State Environmental Planning Policy (Transport and Infrastructure) 2021
State Significant Development Application - SSD-76555711
3-5 Help Street, Chatswood
Request for additional information

16 July 2025

No. 1 CAMBRIDGE LANE
EASTERN ELEVATION

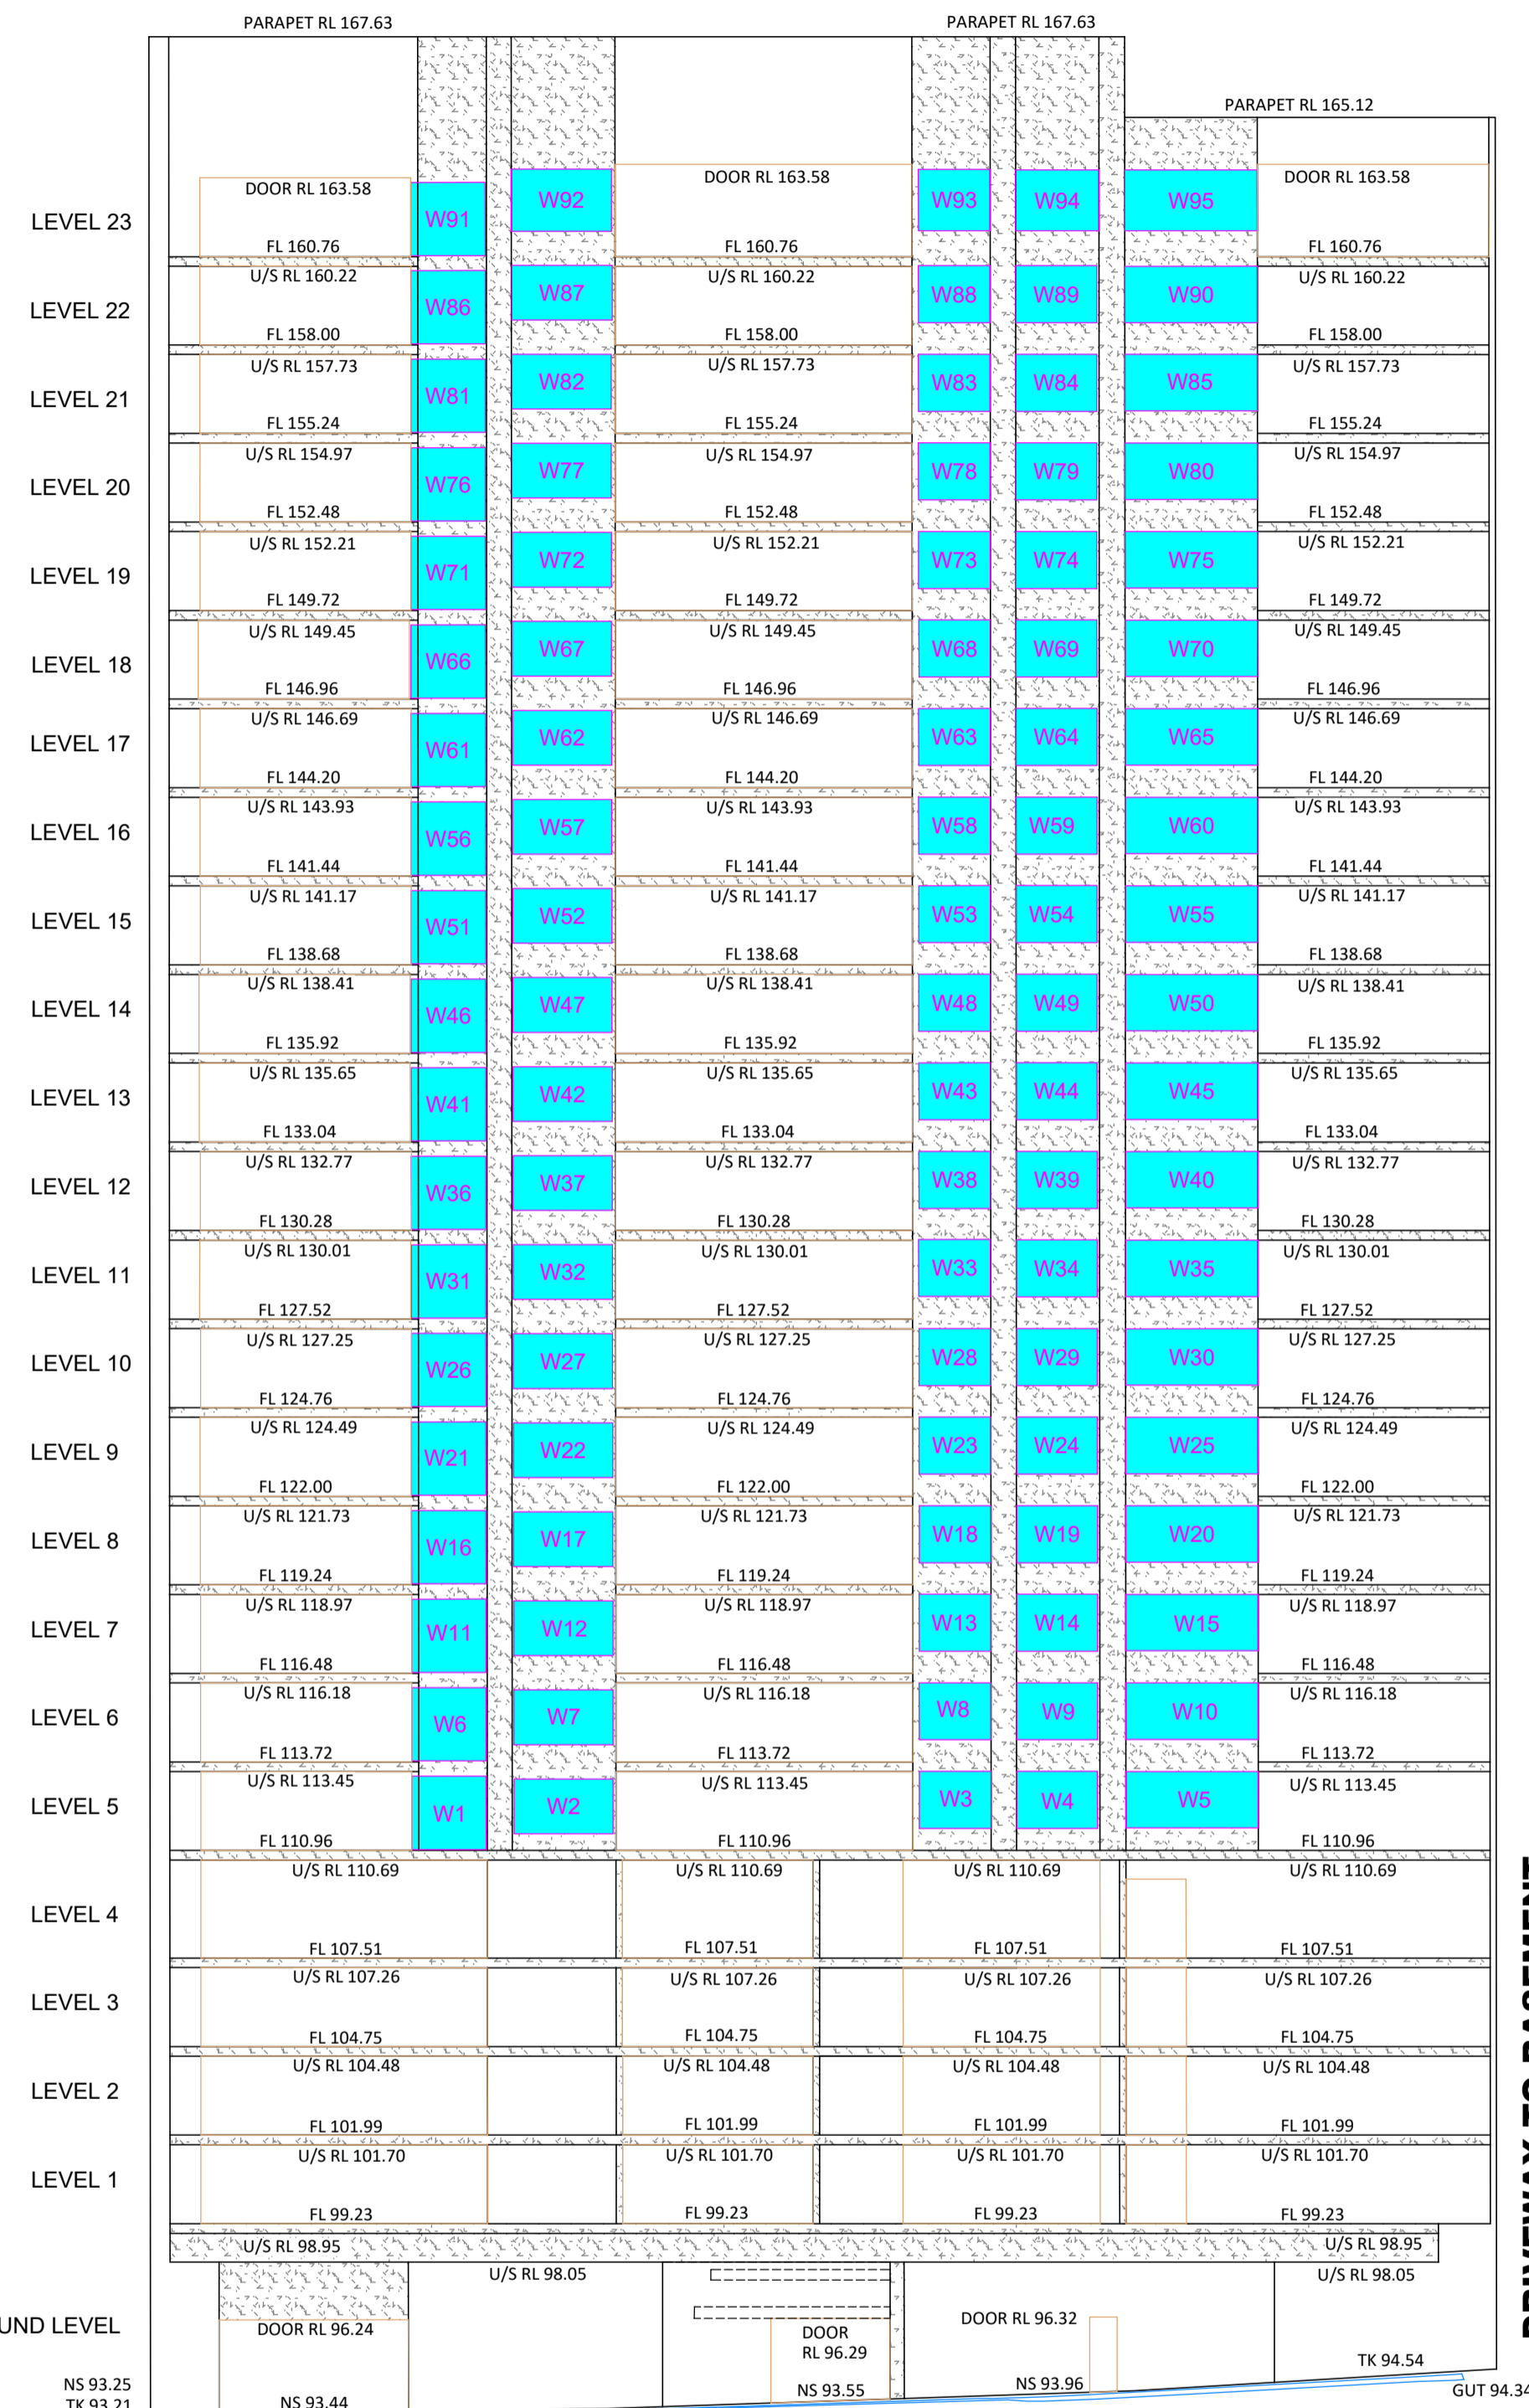
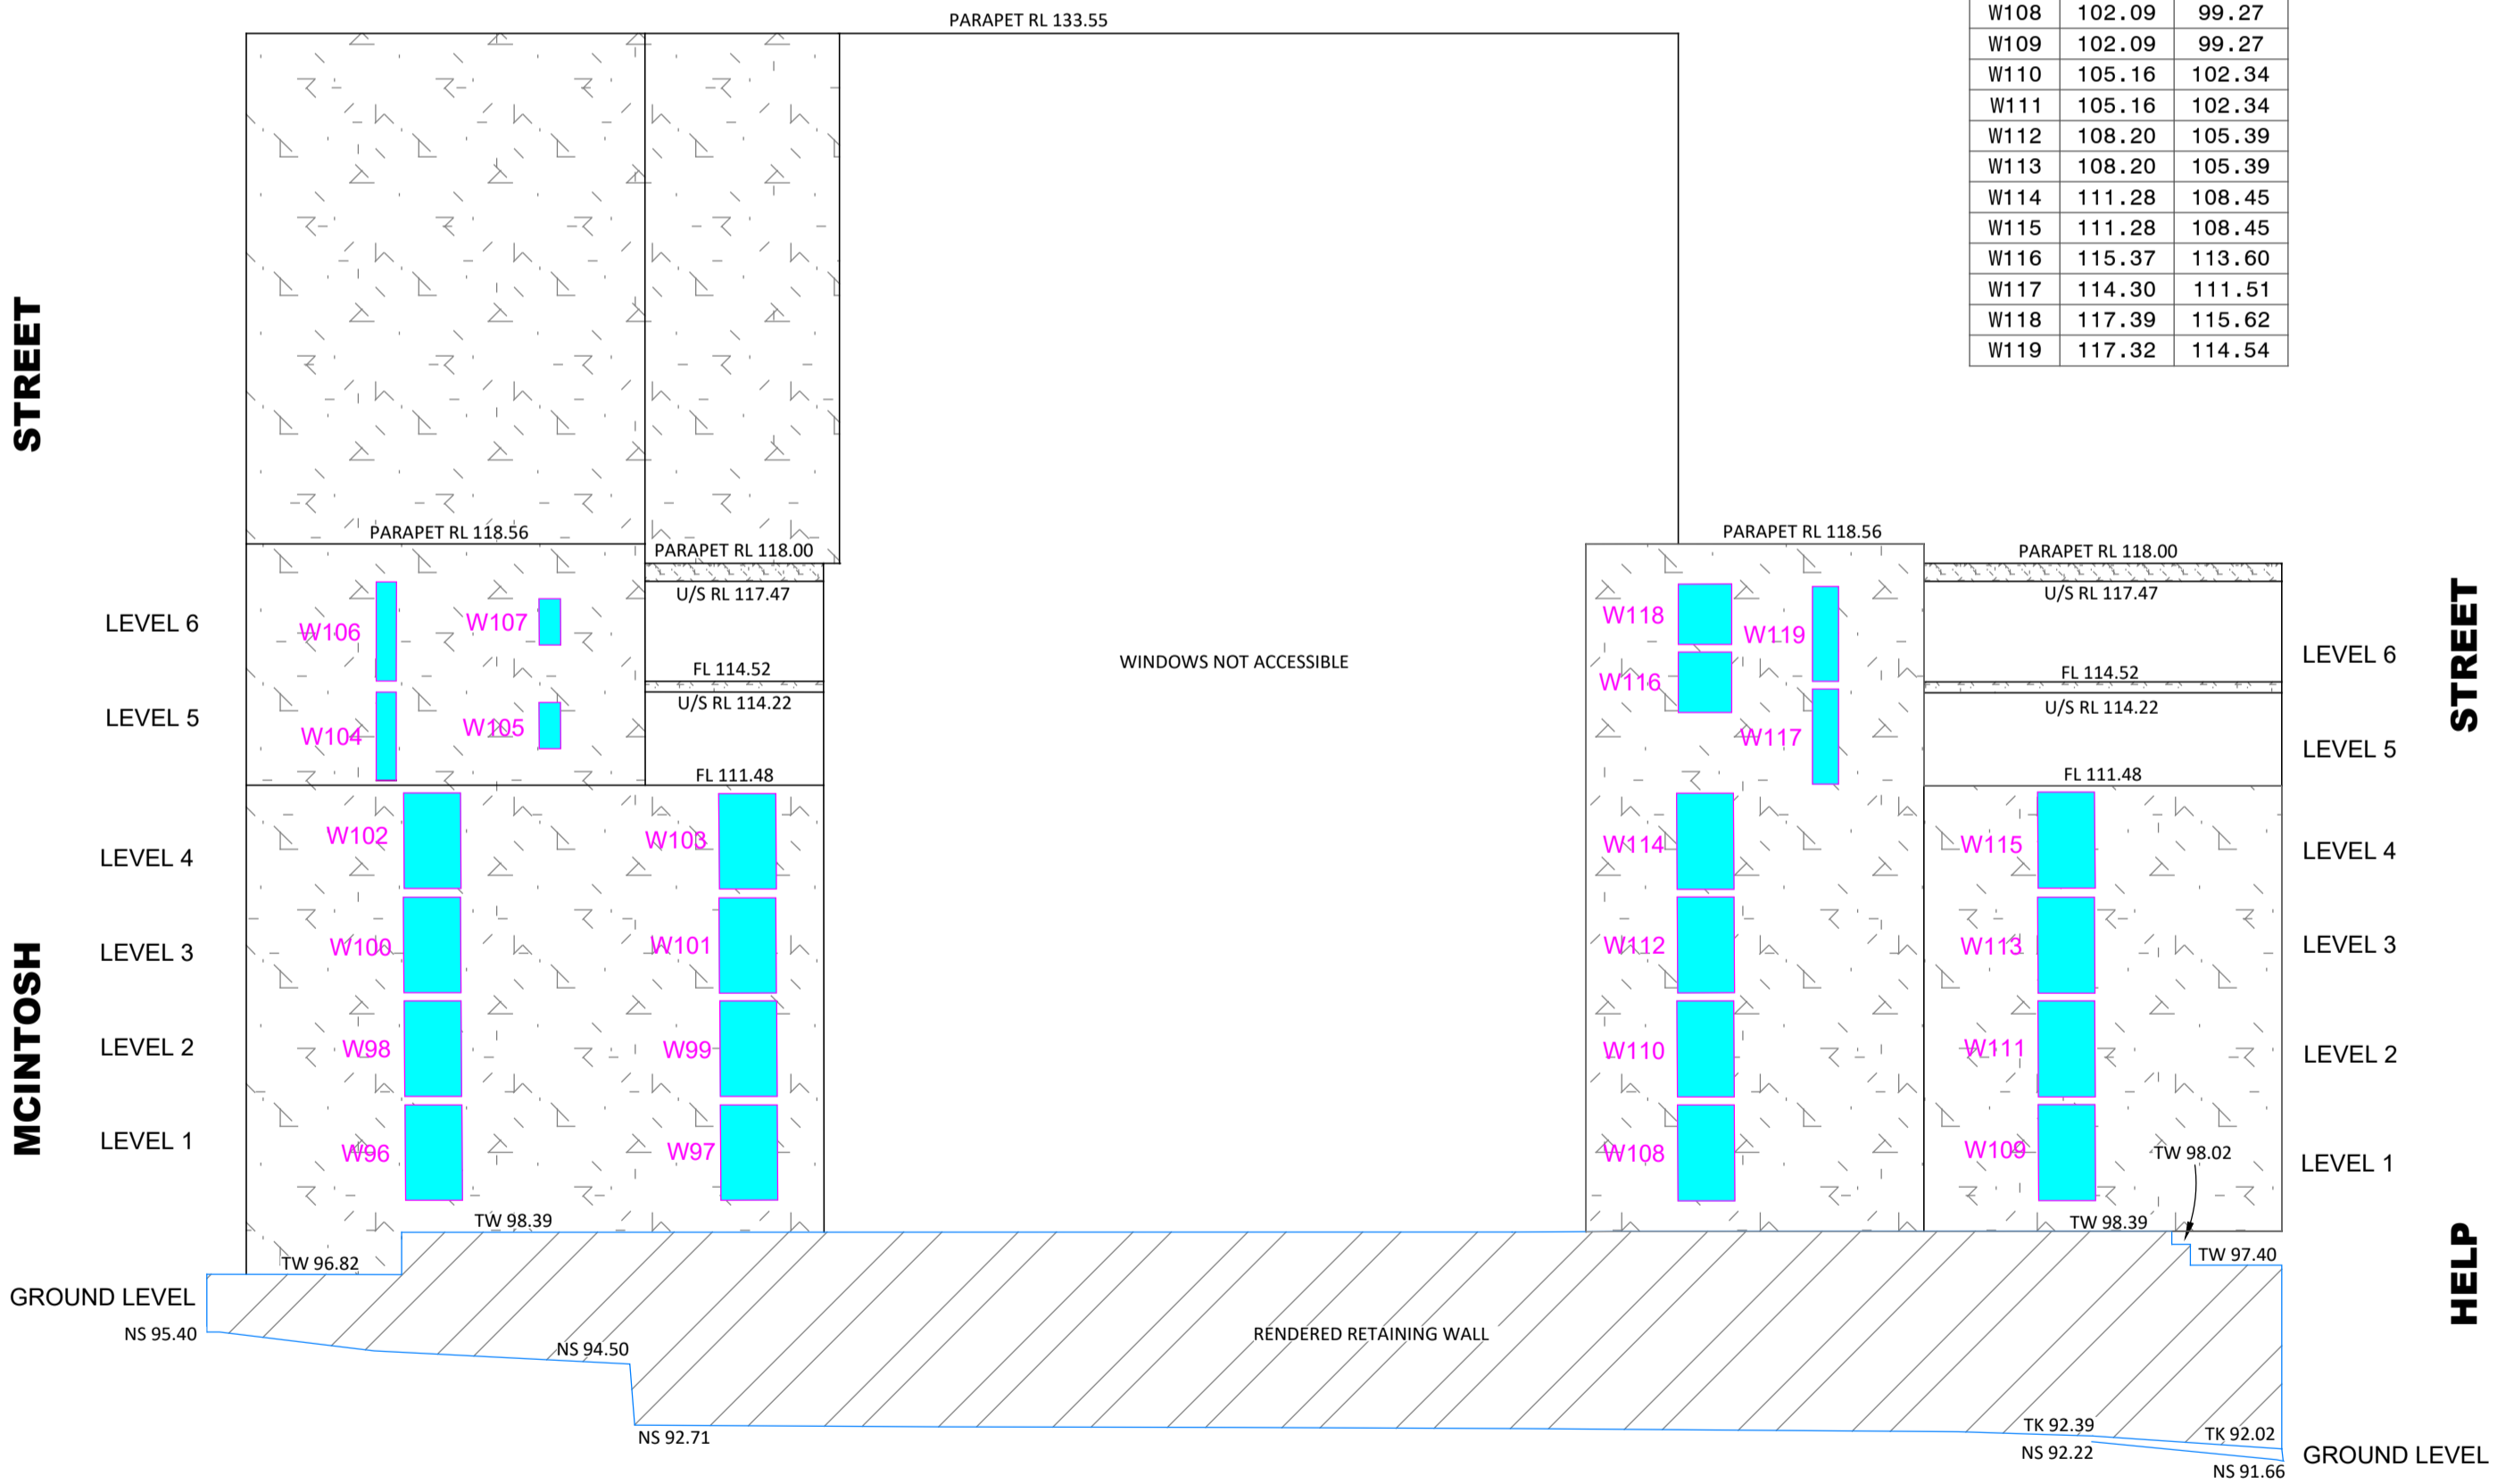
- a) **Survey Plan:** a registered surveyor verified detailed survey information showing the distance of the development to the rail corridor, specifically plan and elevation.
- b) **Ground Anchors:** confirmation of the extents of ground anchors, if required for shoring design.
